From: Pendry, Glenn <[REDACTED]>
Sent: 06 August 2020 09:25
To: [REDACTED]
Cc: Anita Gardner <Anita.Gardner@arun.gov.uk>; Juan Baeza <Juan.Baeza@arun.gov.uk>; Lynnette St quintin <[REDACTED]>
Subject: AB/63/20/DOC 74-76 Canada Road, Arundel, West Sussex BN18 9HY - Planning Conditions 4 & 8

From: Anita Gardner <Anita.Gardner@arun.gov.uk>
Sent: 30 July 2020 11:32
To: Pendry, Glenn [REDACTED]
Subject: *EXTERNAL: AB/63/20/DOC Canada Road, Arundel

Local Highways Comments pertaining to Condition 4 (site layout).

With regard to condition 8 it is noted that the plan is annotated to demonstrate a 13.8 metre VCO.

- Indicates Site Cabin - Oasis Unit Location
- Indicates Proposed Materials offloading Area to Storage Area/s.
- Indicates Proposed Materials Storage Area
- Indicates Proposed Contractor Parking Provision (on-street)

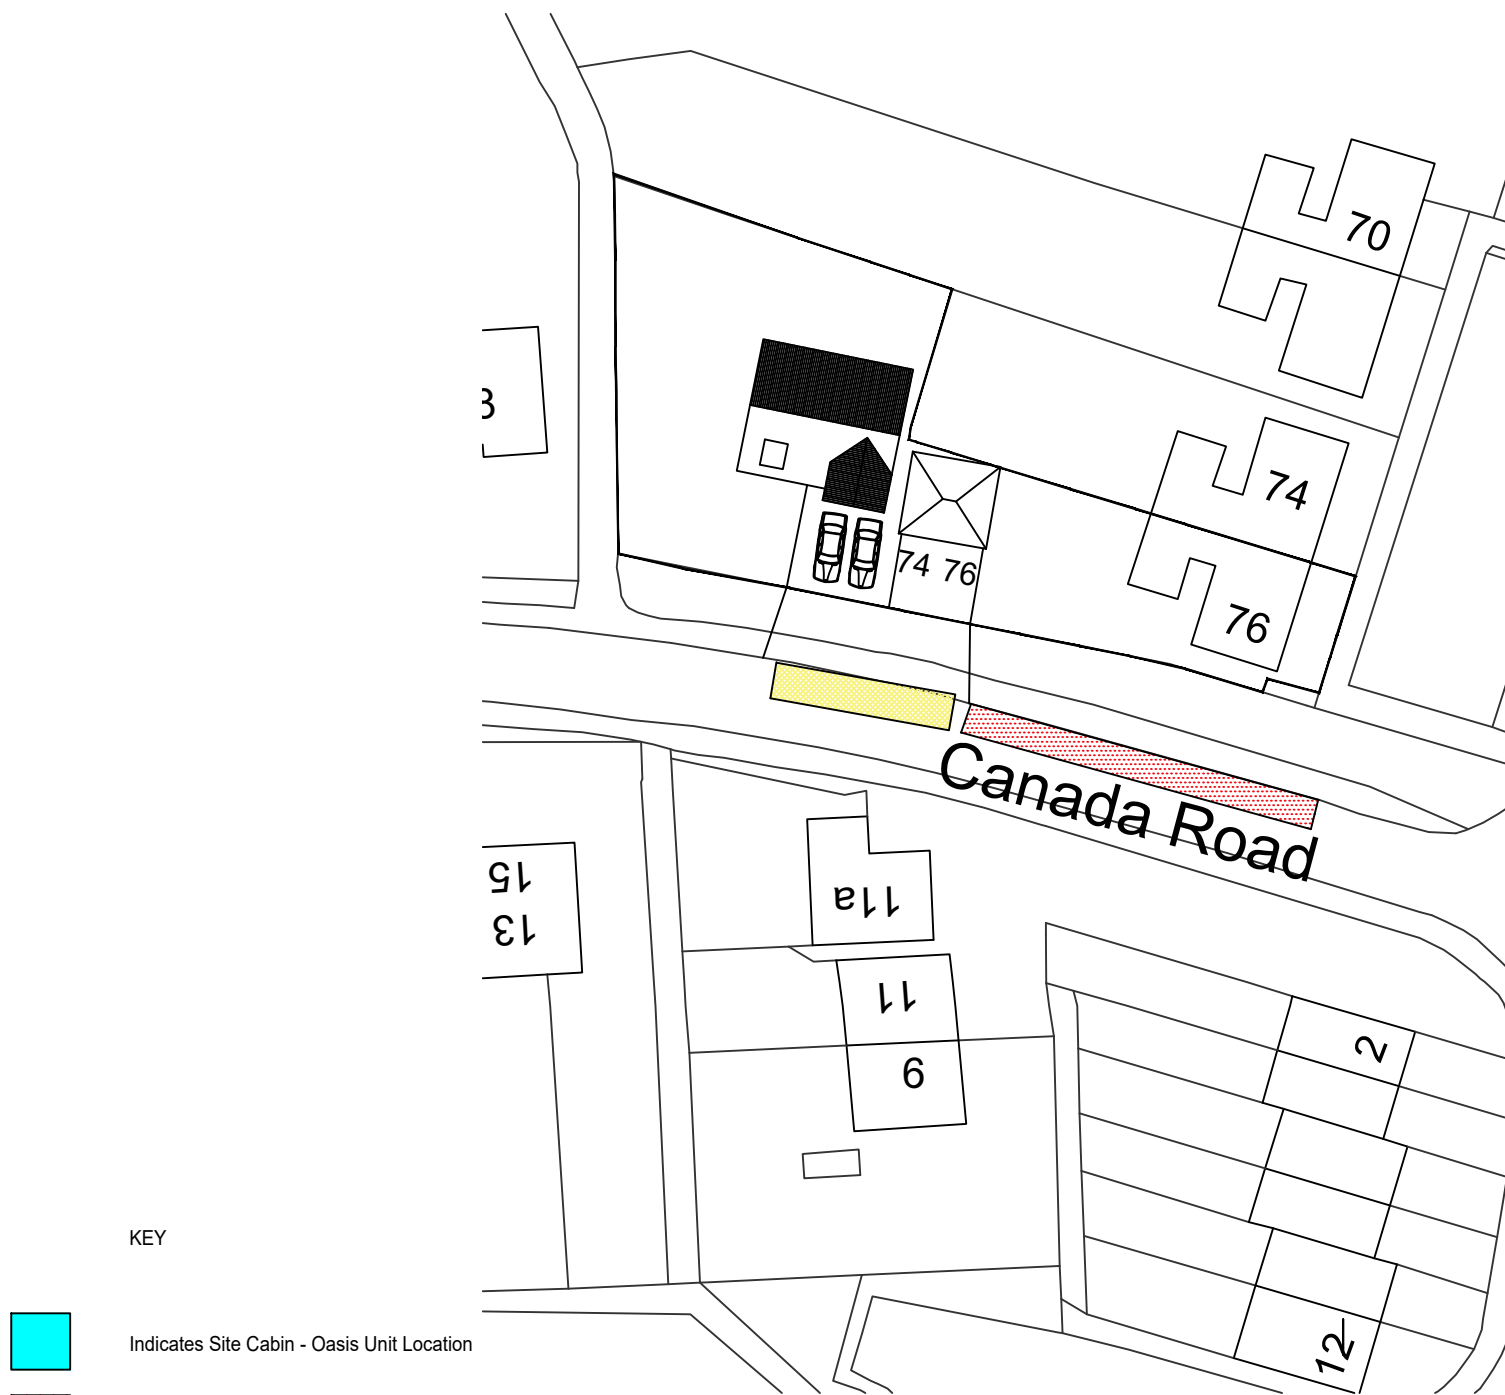
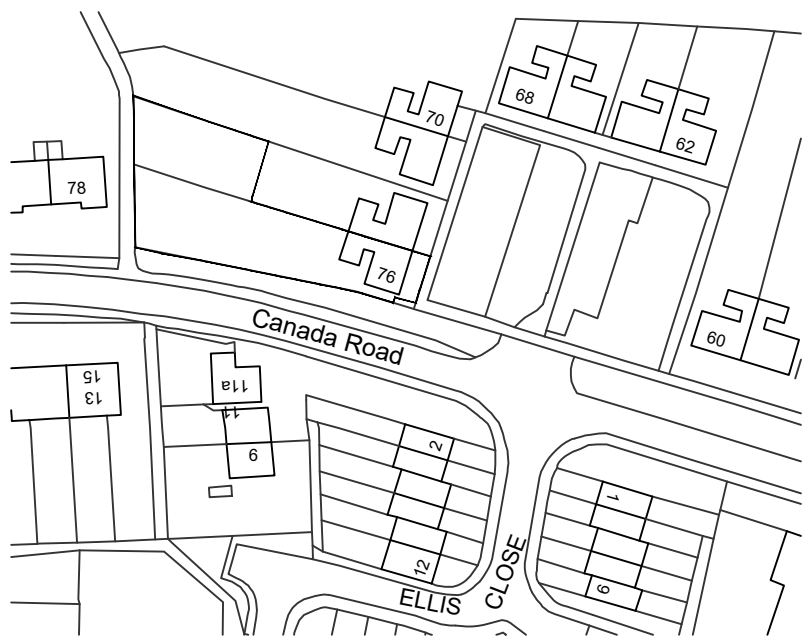
The LHA does not accept storage of materials within the publicly maintainable highway. The LHA asks the applicant to amend the plans.

The LHA does not accept parking provisions for workers within the highway, please amend.

Drawing No.	Status
15718-HOP-ZZ-XX-DR-C-10008	S0 P3

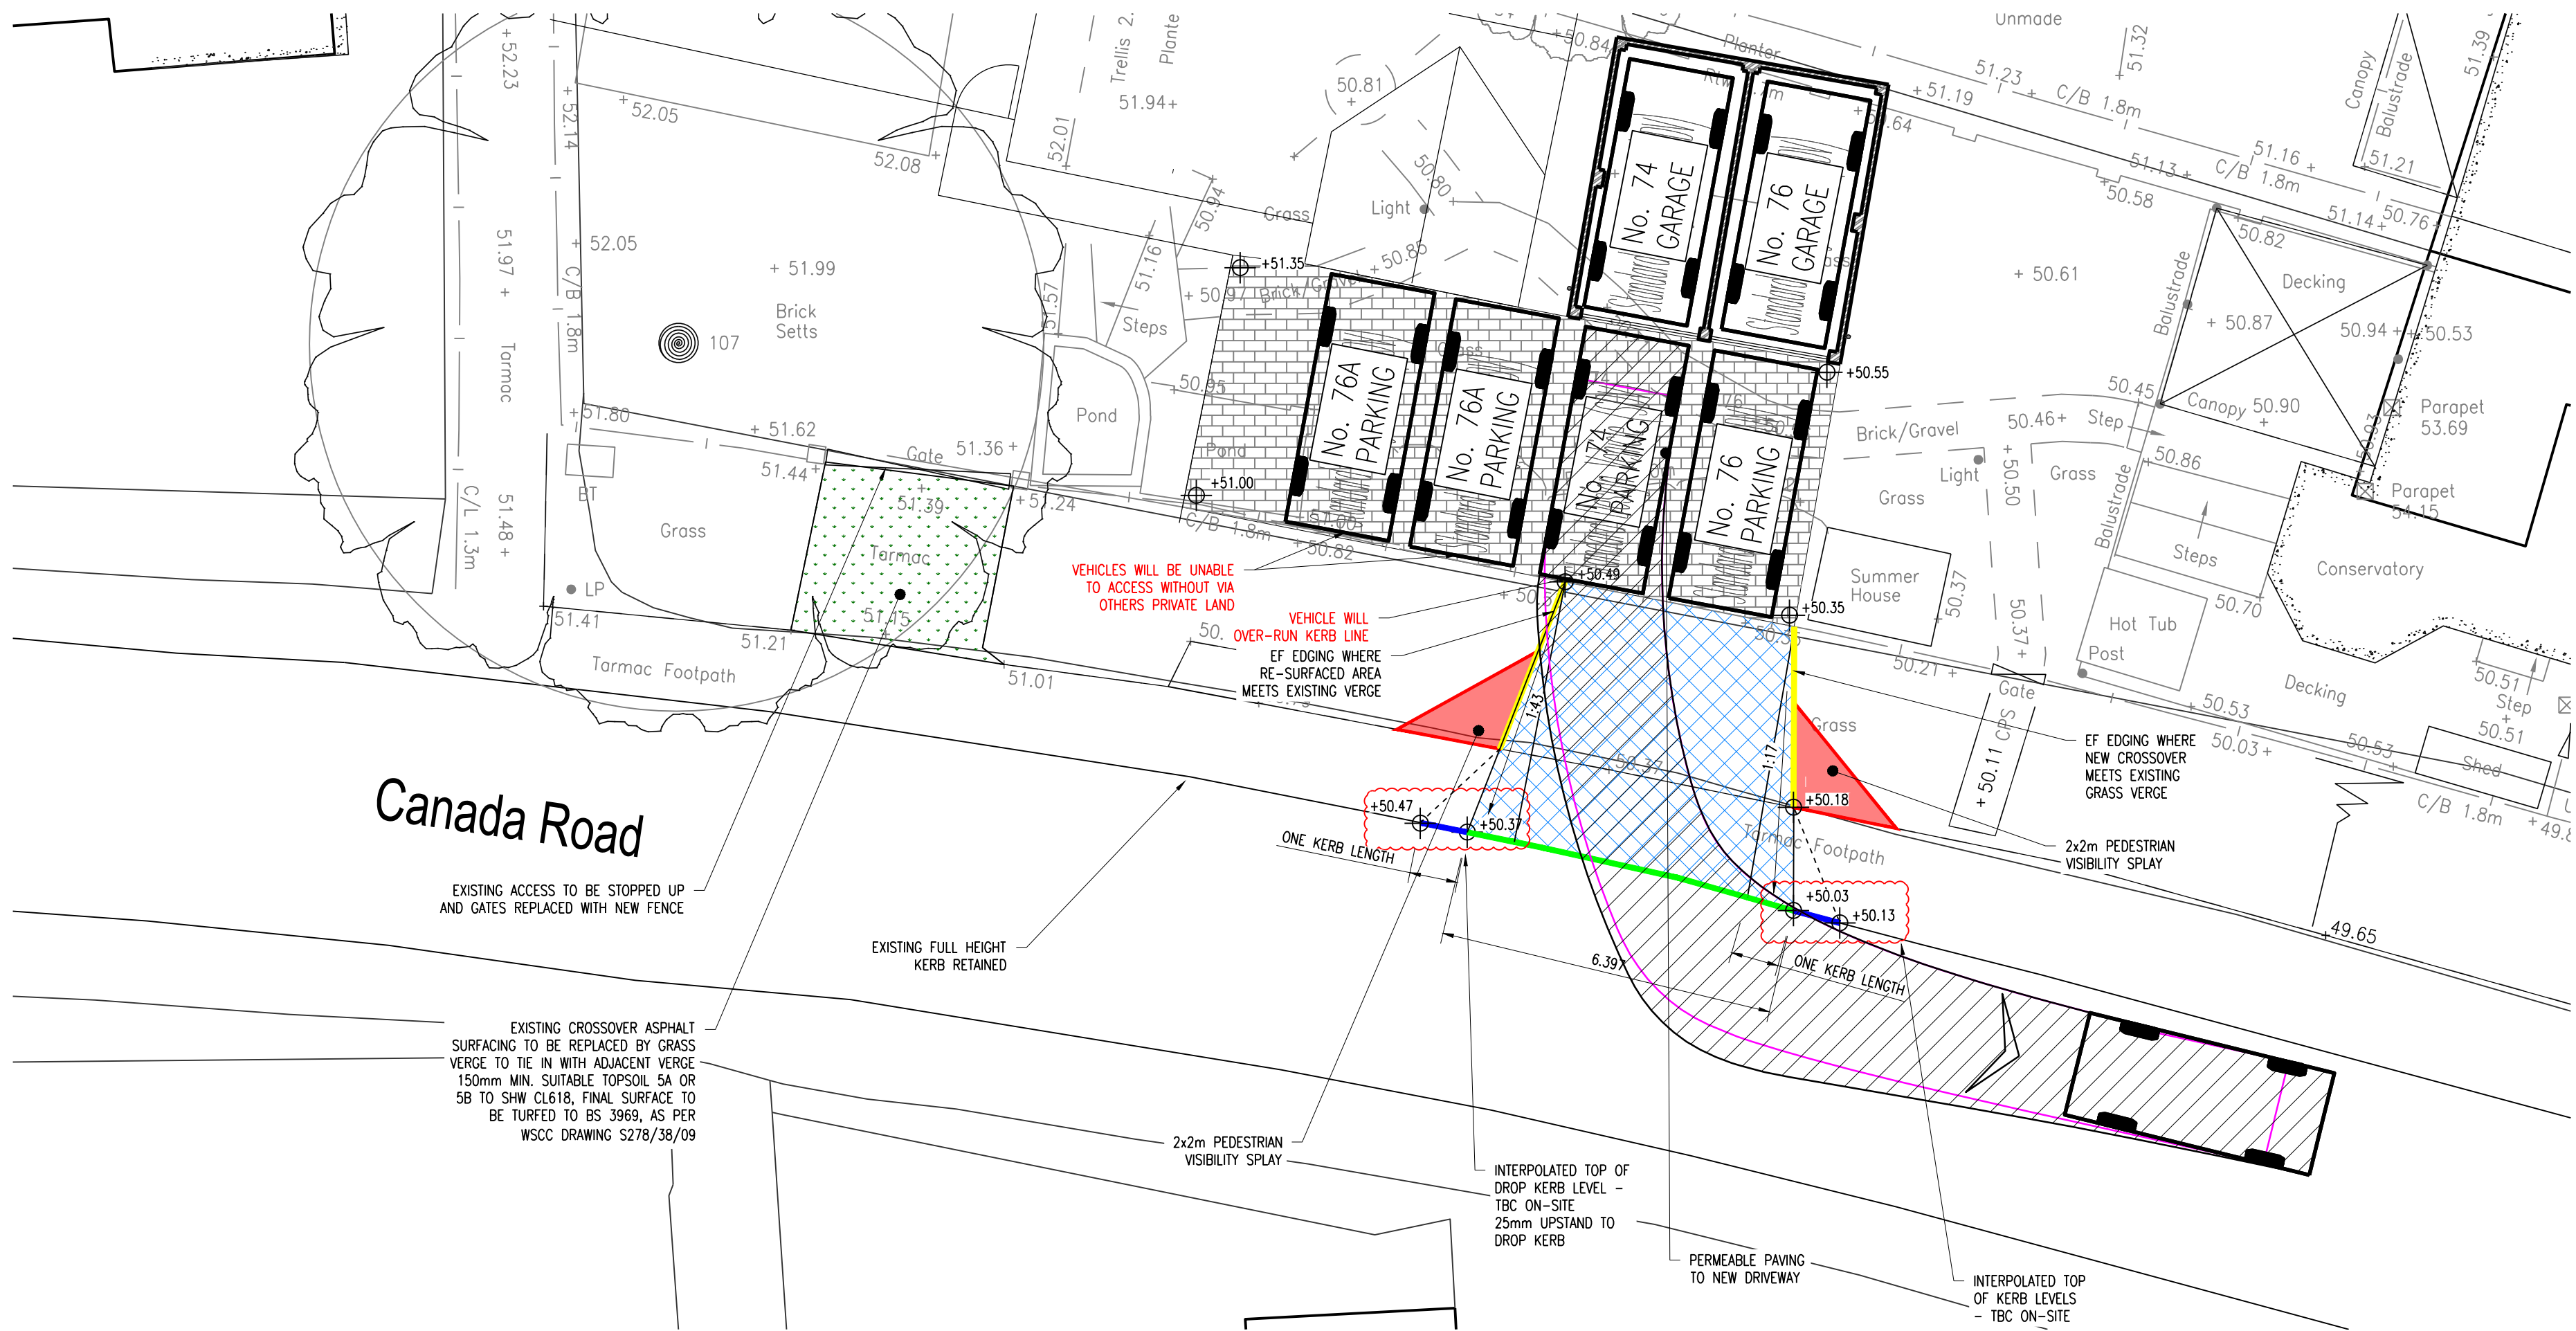
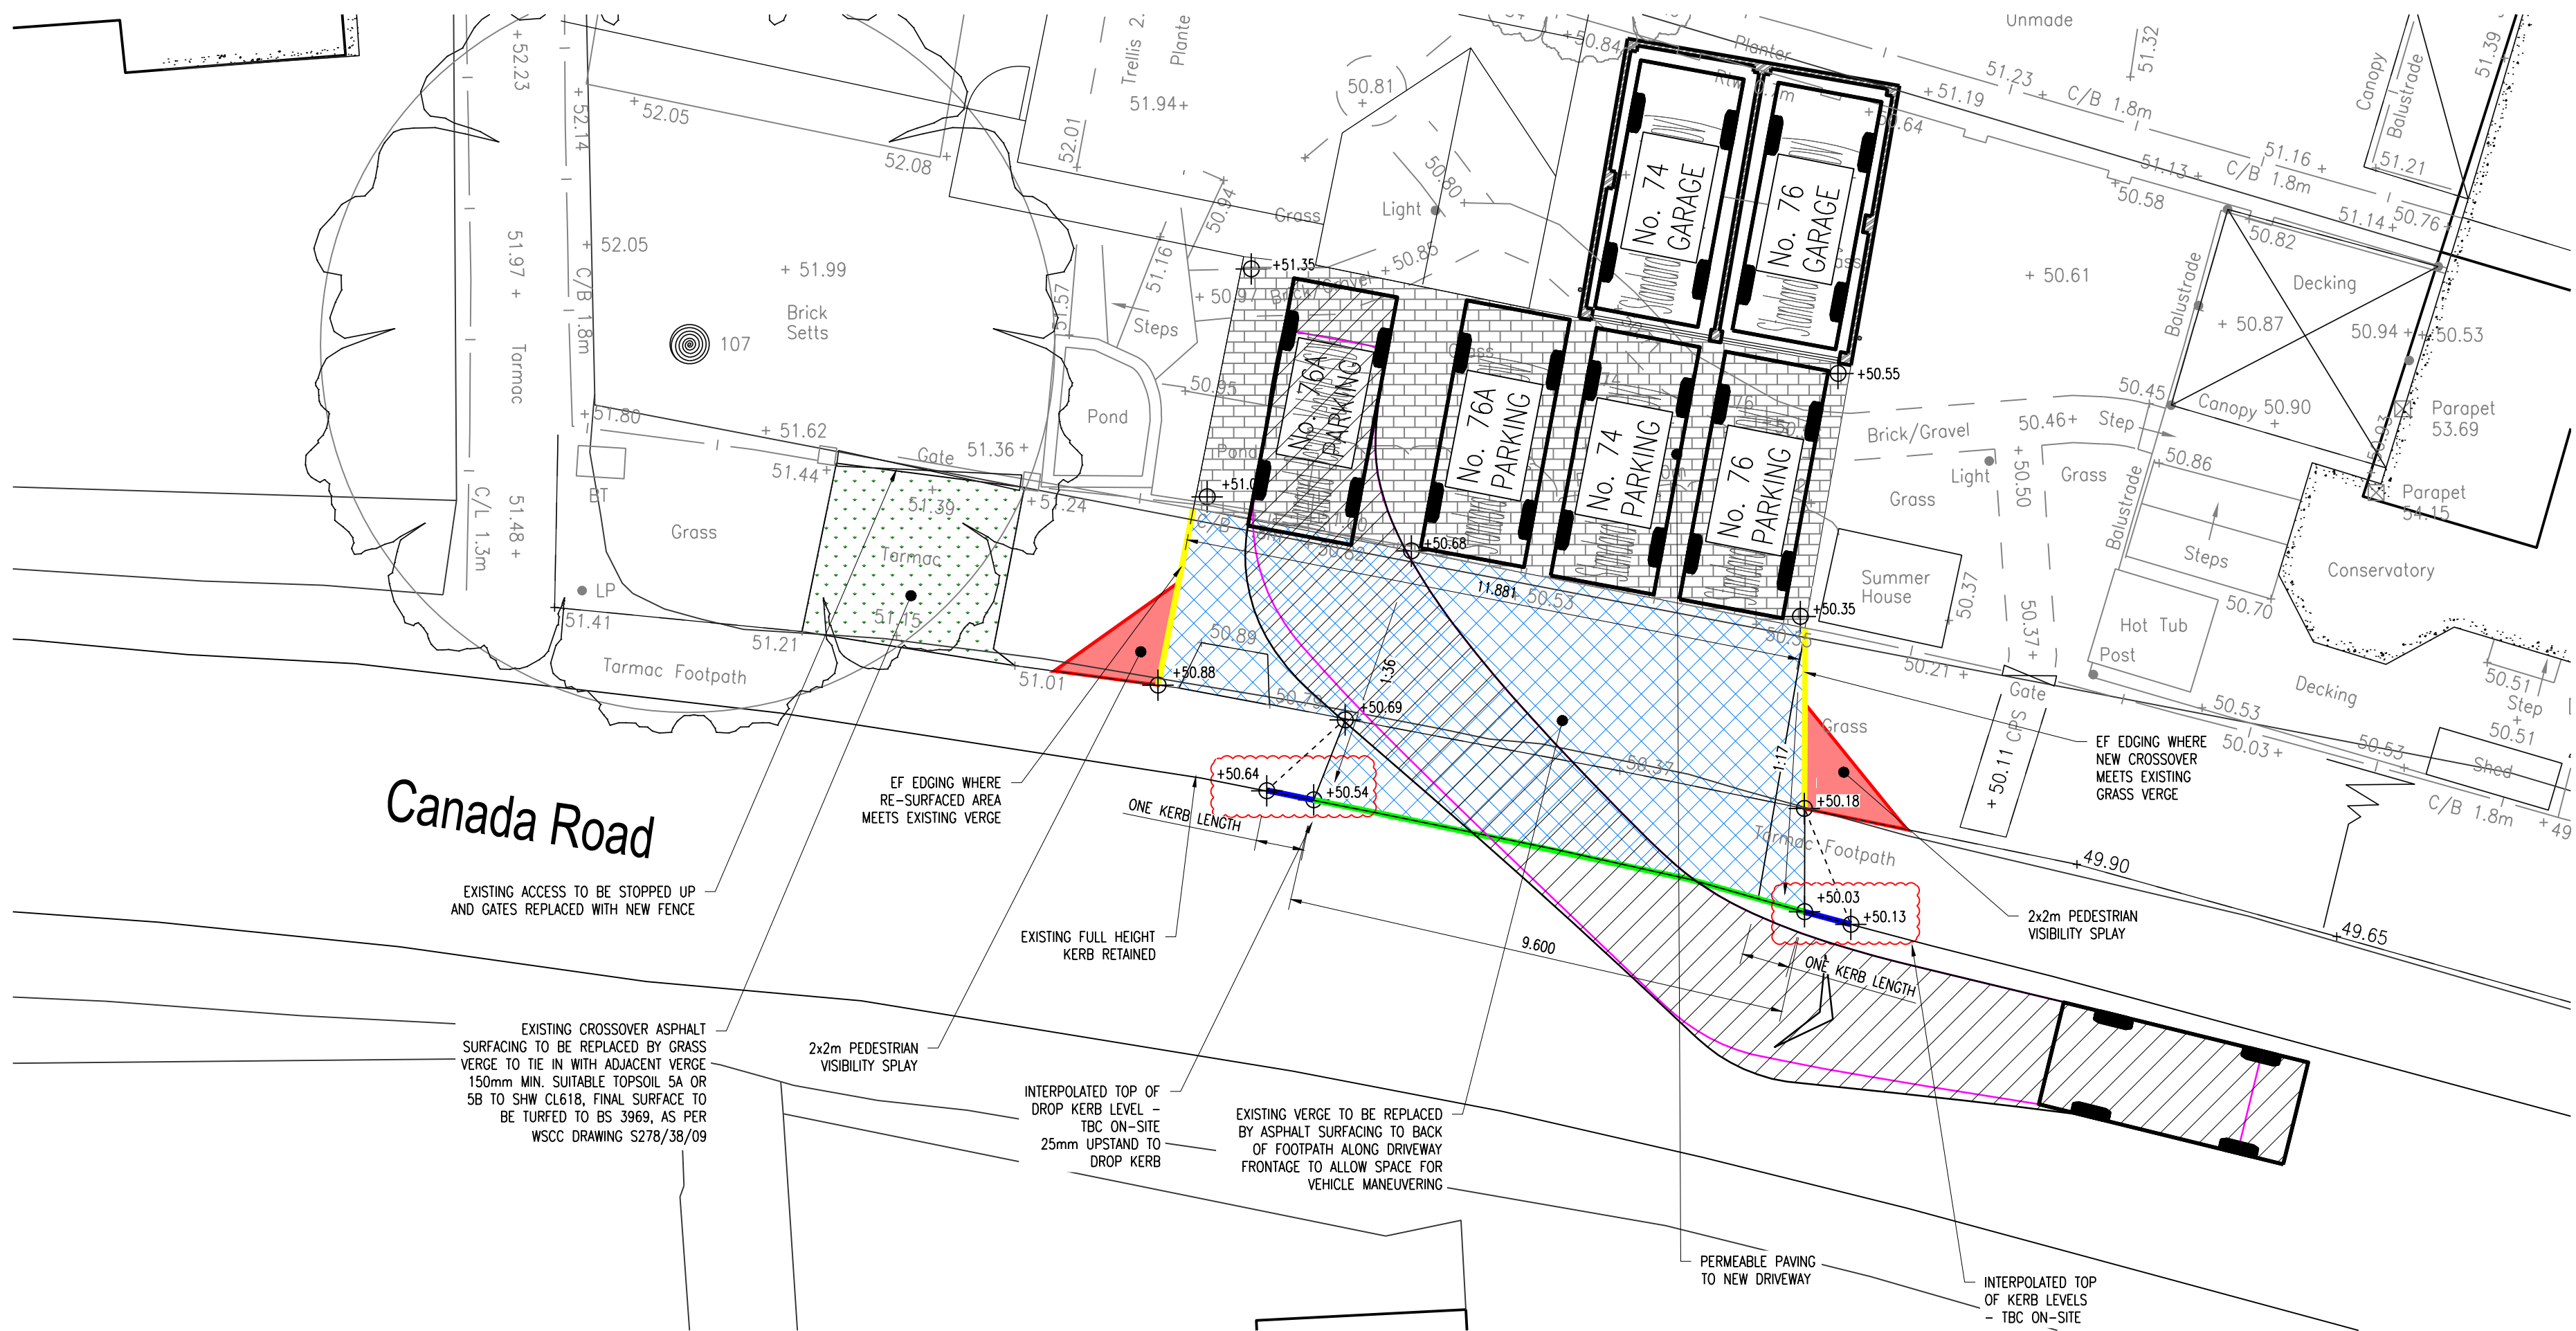
WSCC Highways Area Office, who is responsible for the issuing of VCO Licenses, do not wish to see VCO's measuring over 6.4 metres in this location due to the existing parking

pressures and the loss of on-street parking provision for neighbouring residents. While this is not a highways safety issue the LHA wish that good planning practices are kept

and as such, no planning application is permitted where it cannot be implemented. As a result, the LHA advises the applicant to reduce the VCO to 6.4 metres maximum.

The LHA requests the applicant modifies the plans to reflect the above comments.

However in this regard and having again reviewed the approved planning drawing (attached for reference), I don't feel as the crossover serves parking for 3 separate properties, namely that of the new residential property together with N's 74 and 76 Canada Road that this could be reduced to 6.4m and still allowing safe access and adequate manoeuvrability to these.

As such could I ask that the extent of this be reconsideration, allowing an O/A width at the channel line of 9.6m resulting in an O/A reduction of 4m in length.
